APPLICATION CONSULTATION RESPONSE

Application Number:	3/2018/0138
Location:	Standridge, Wigglesworth Road, Slaidburn, BB7 4TR
Proposal:	Erection of an agricultural building for free range egg production together with associated feed bins and hardstanding areas and access.

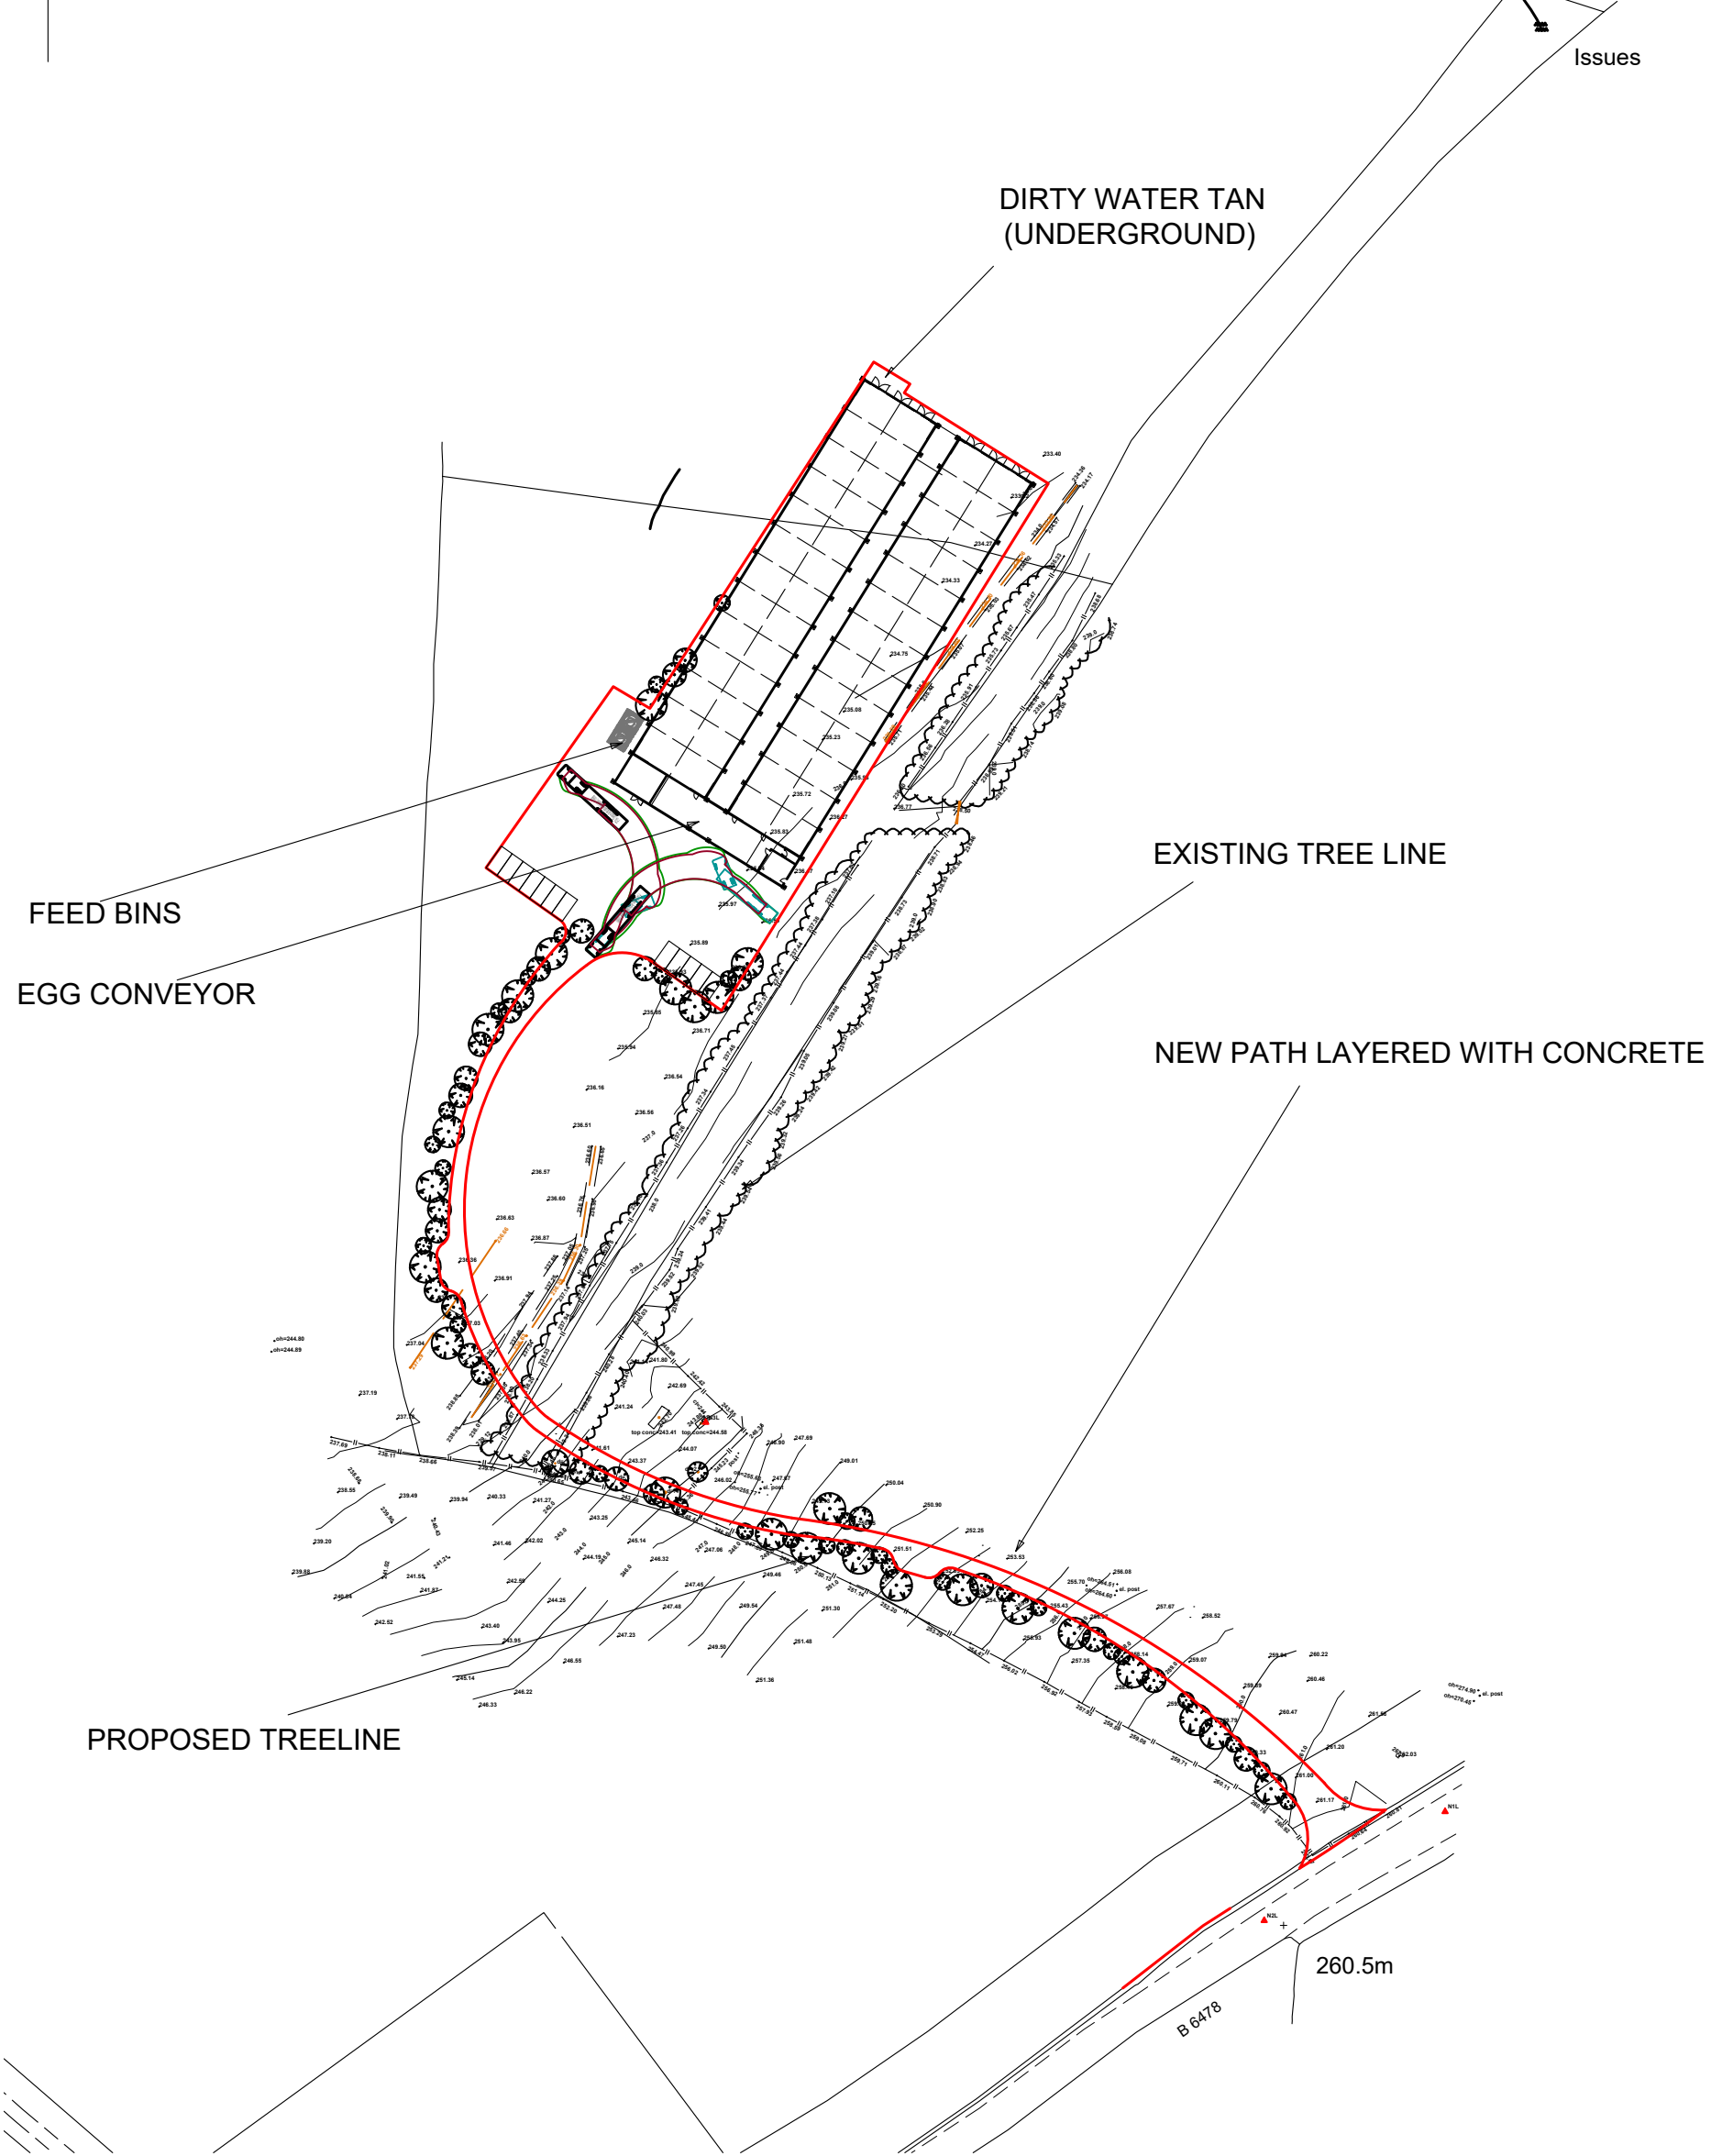
An indicative site drainage strategy, including: • Preliminary sustainable drainage proposals • Existing and/or proposed sewers, drains and watercourses • Surface water outfall locations • Pre-development and post-development surface water discharge rates • On-site storage requirements	X
A proposed site plan showing flood water exceedance routes and identification of catchment area(s)	X
Site investigation report, including the results of each sustainable drainage system feature of: • Borehole or Trial pits • Infiltration (permeability) testing • Factual Ground Investigation Report (GIR) • Geotechnical Design Report (GDR)	X
Drawings and calculations, including: • Details of inlets, outlets and flow controls • Long and cross section drawings of proposed drainage system(s), including design levels • Details of appropriate water quality treatments • Sustainable drainage system flow calculations (PDF files showing the input and output data for flow calculations) and storm simulation plan for: 1 in 1 year, 1 in 2 year, 1 in 30 year and 1 in 100 year + 30% climate change.	X
